From: Simon Davis
Sent: 01 March 2019 16:03
To: Planning.Responses
Subject: FW: BR/311/18/PL Chichester University
Attachments: 151933-STL-00-XX-DR-A-ZZZZ-17004_Site Plan with Hook Lane overlay.pdf; 151933_STL_00_ZZ_DR_A_ZZZZ_02007.pdf; 151933-STL-00-XX-DR-A-ZZZZ-V0006_Building superimposed on site photograph....pdf; RE: BR/311/18/PL Chichester University

The attached context elevation drawing (151933_STL_00_ZZ_DR_A_ZZZZ_02007) illustrates the height of the development as suggested as being potentially acceptable in your email below (5 storeys reduced to 3). This highlights that the area that is the focus of the balance between acceptable and overbearing as being relatively small. The approved building is of a large size and the changes proposed are not considered to tip the balance of acceptability and dominate the outlook which would make the project overwhelming/oppressive when you consider the scale of the development as a whole.

Current Scheme (6655) - December 20th 1044hrs

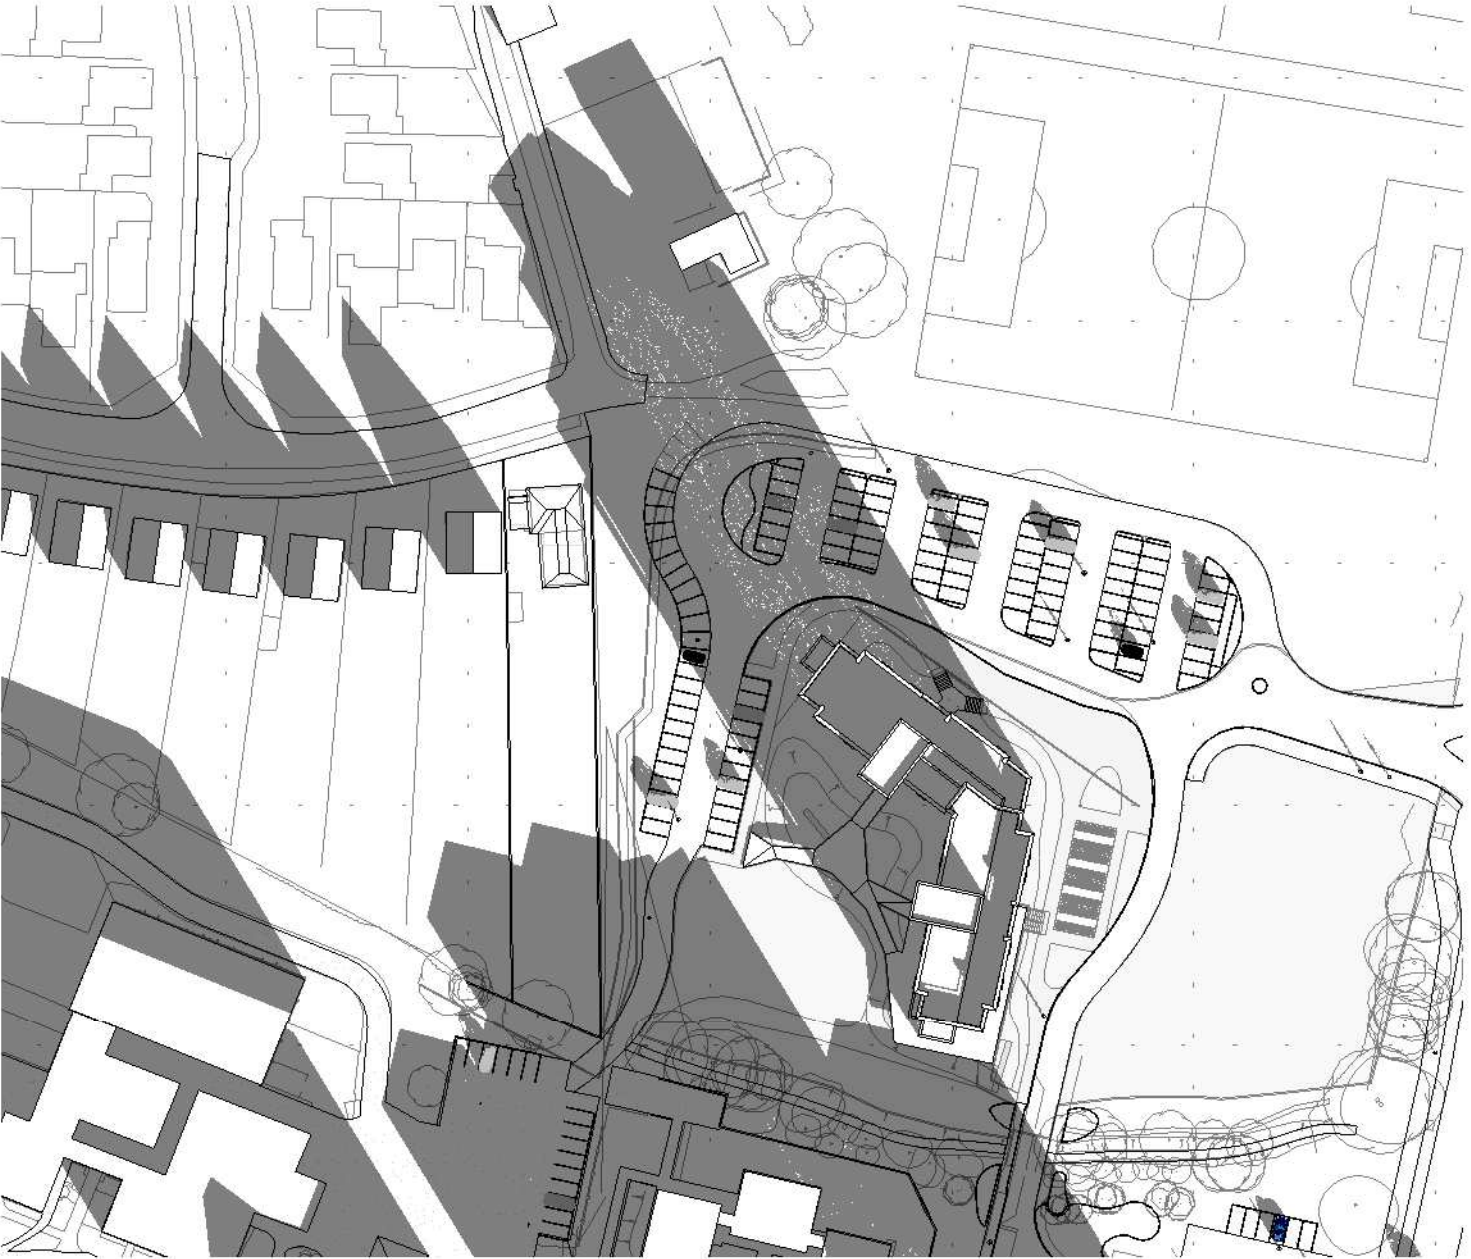
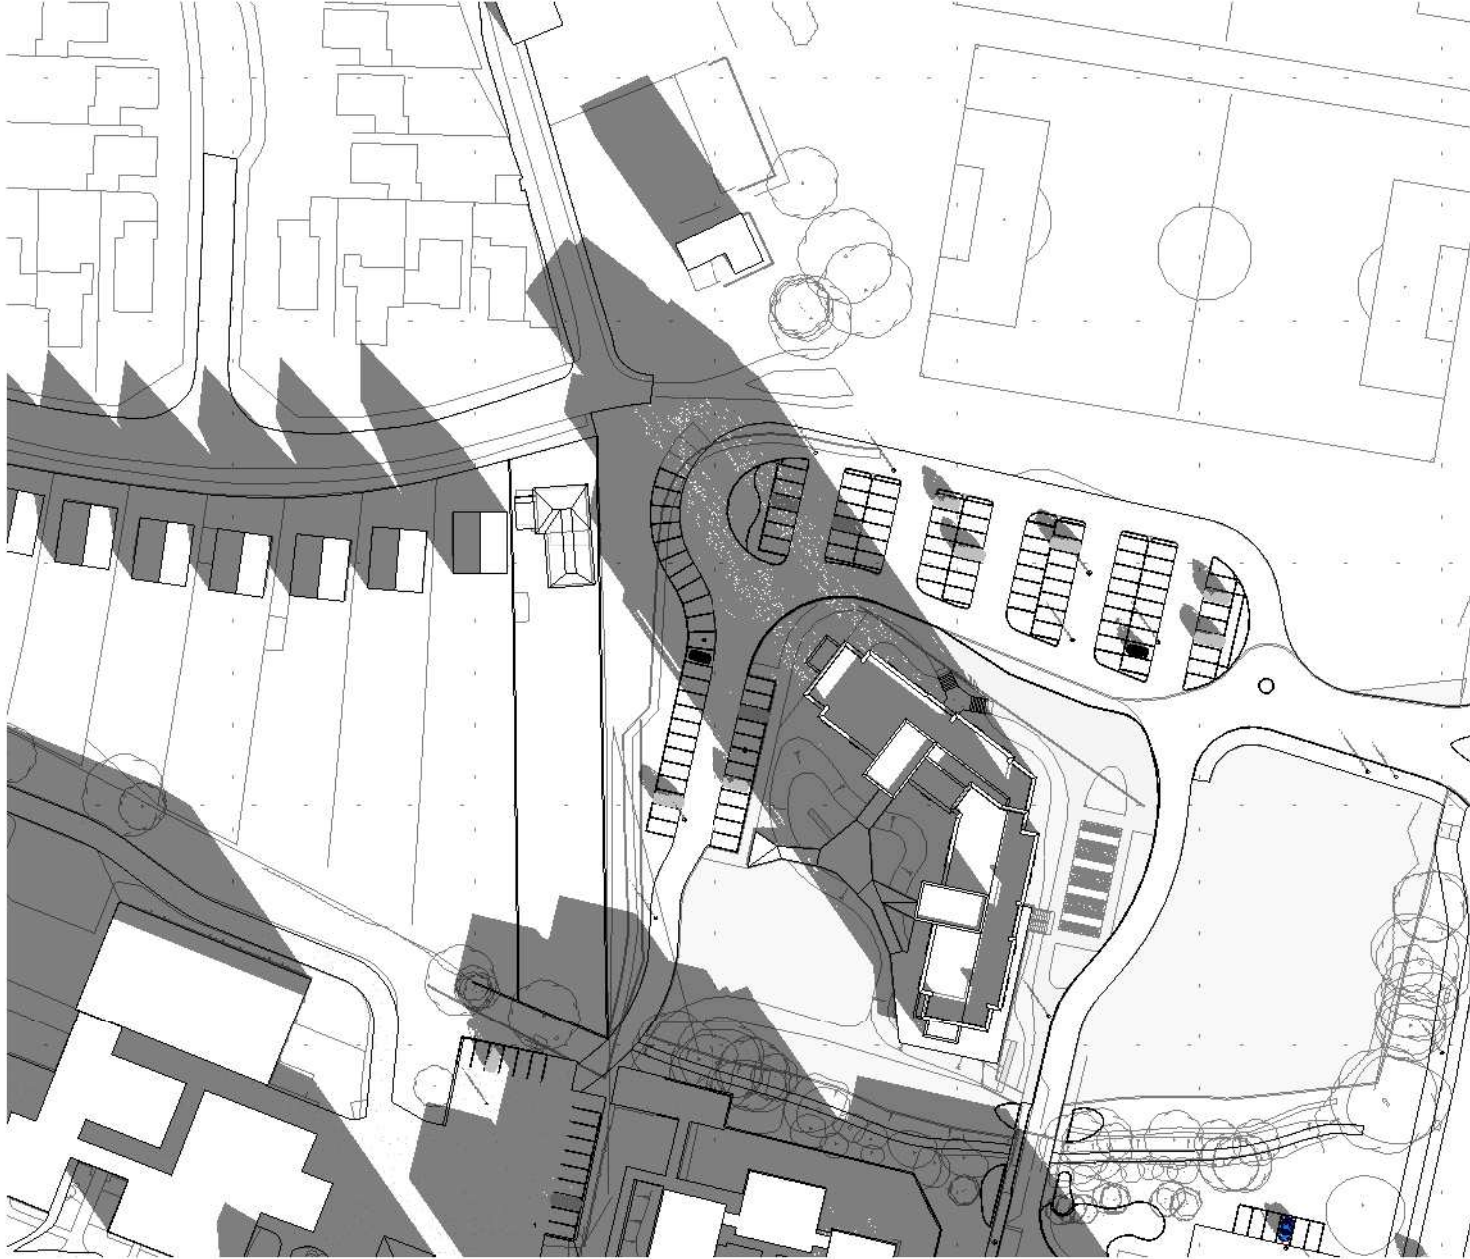
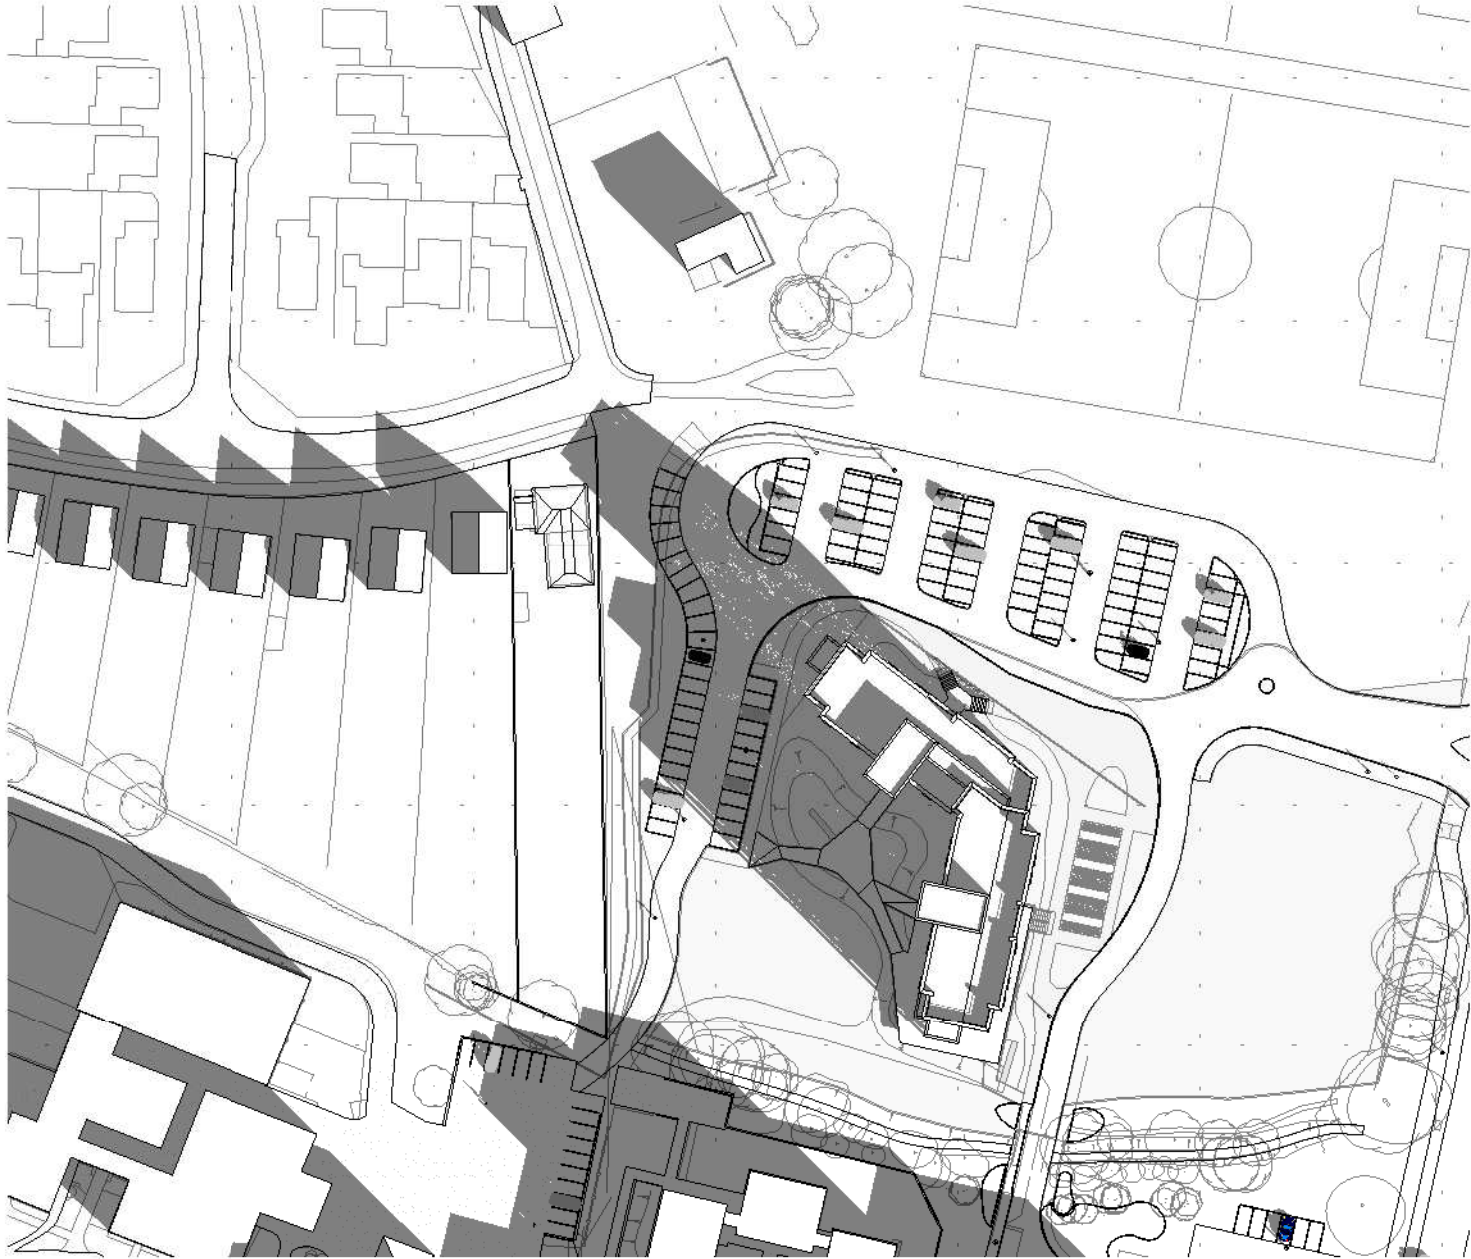
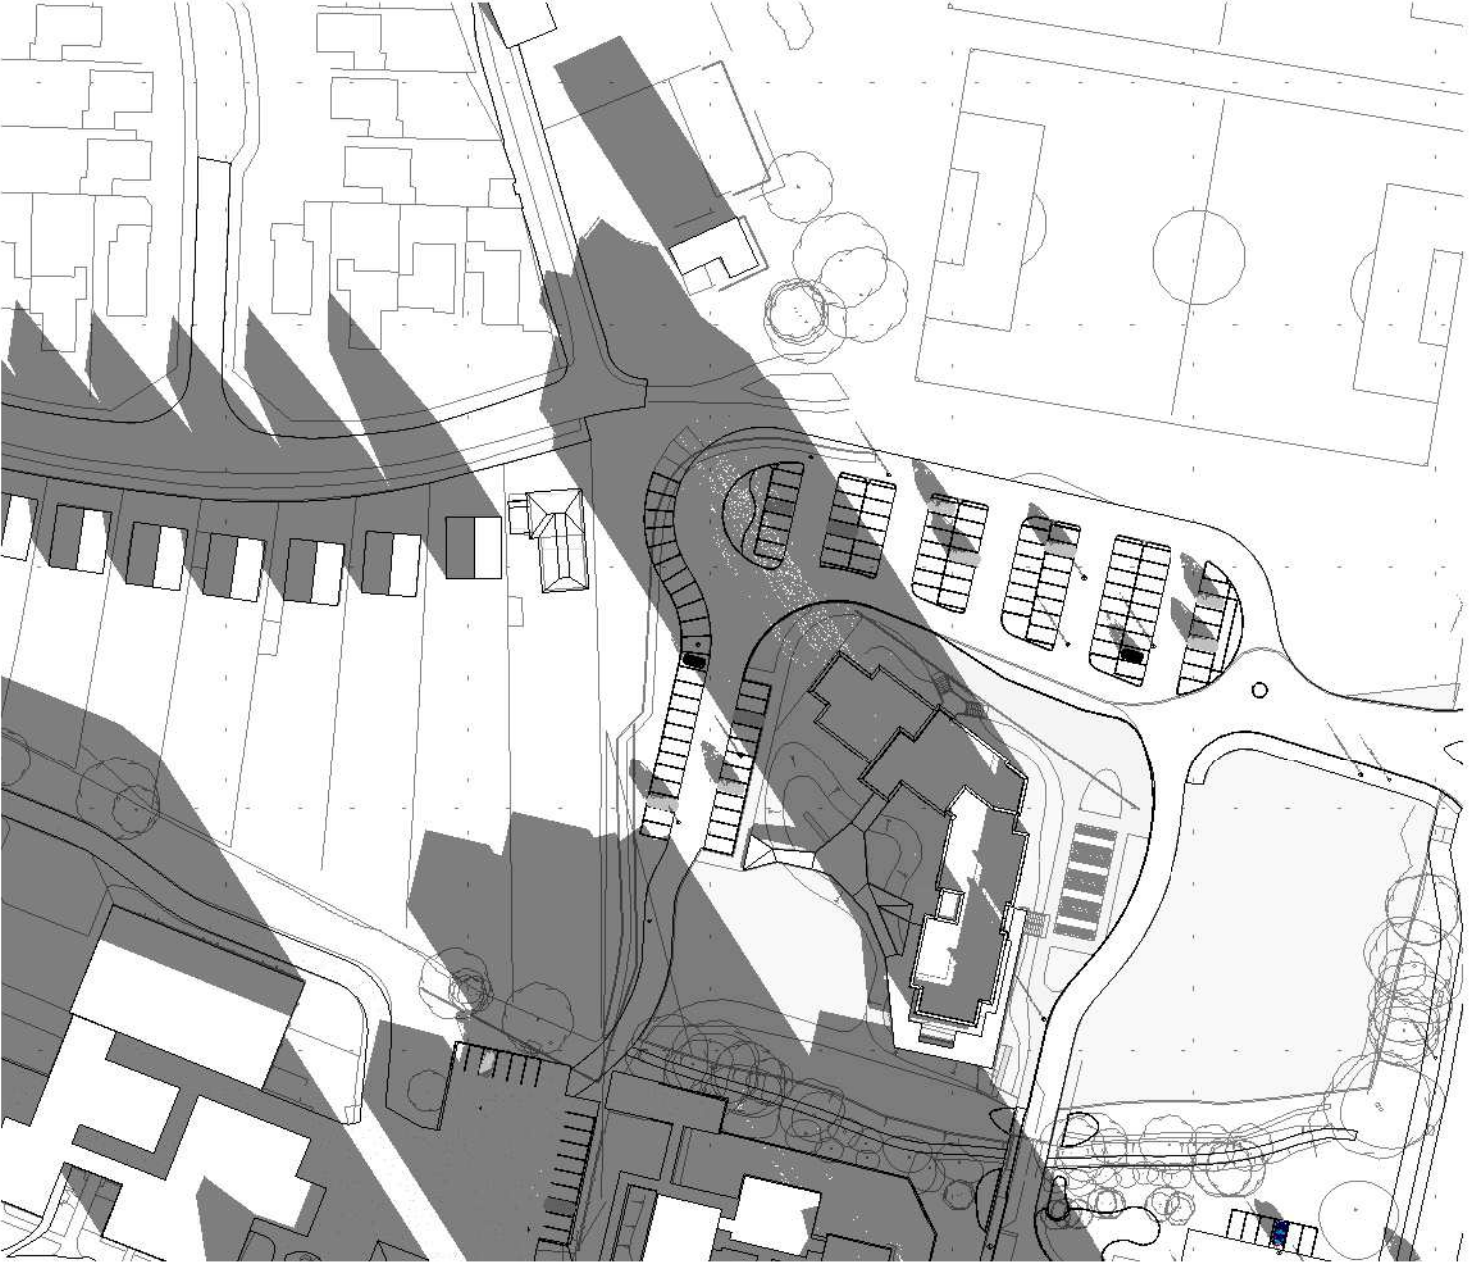
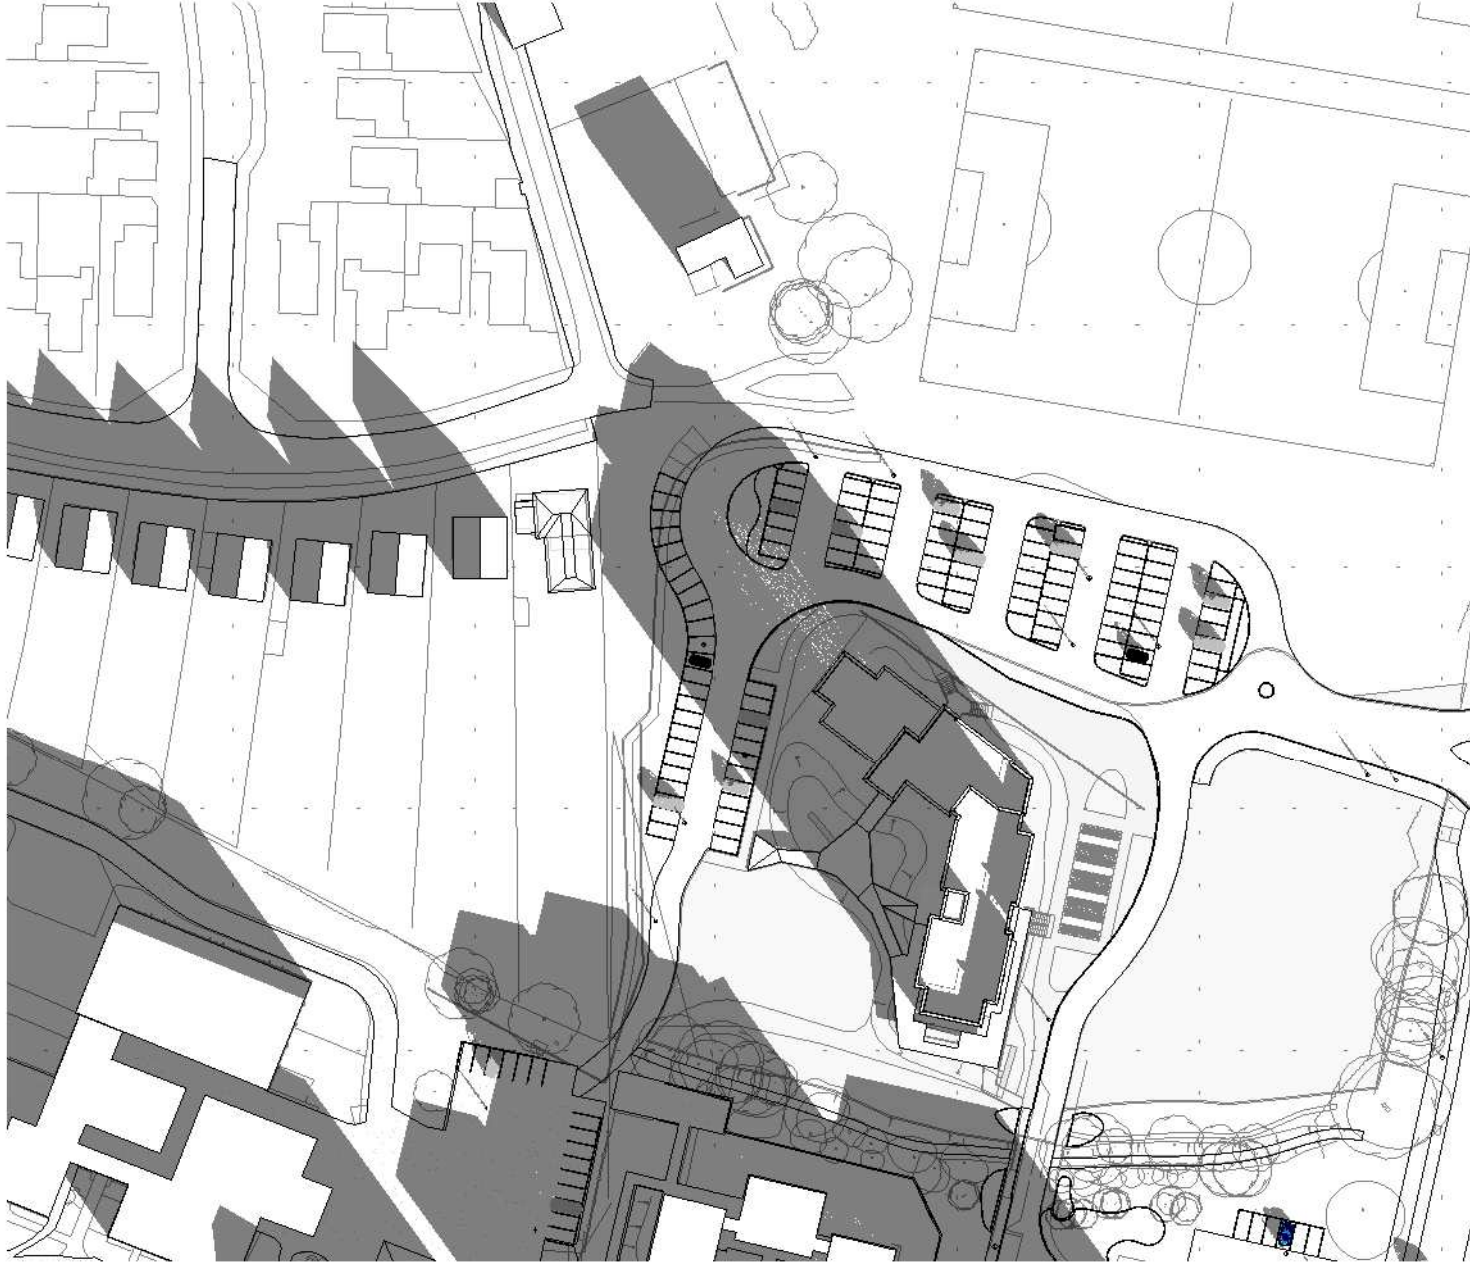
Your suggestion to reduce the end block of Block B from 5 storeys to 3 storeys highlights that this is the key area of concern and which we will seek to address.

To assist in visualising this in context, we have today visited site to take a number of photographs from the University side of the boundary fence, setting out the corner of the proposed building and marking this with a 4m high staff, to ensure reasonable accuracy in determining its height. We have used this to show our building in context, and attach an image with the proposed building superimposed on the site photograph. For record purposes, the photographs were taken at 10:45am on 26th February. Notwithstanding the fact that there is a close boarded 1.8m high fence between this position and the bungalow behind, which will obscure most of this view, and the bungalow is set slightly further away than the origin of this photograph, in our opinion, this shows the scheme to be acceptable, both in terms of its massing and shadowing.

The proposals seek a circa 5.5 metre increase in height across the end habitable part of block B (i.e. 392m²) this increase within the context of a 5240m² scheme is not considered to render the proposals unacceptable where it results in a 7.4% increase in the floor area of the building at this point.
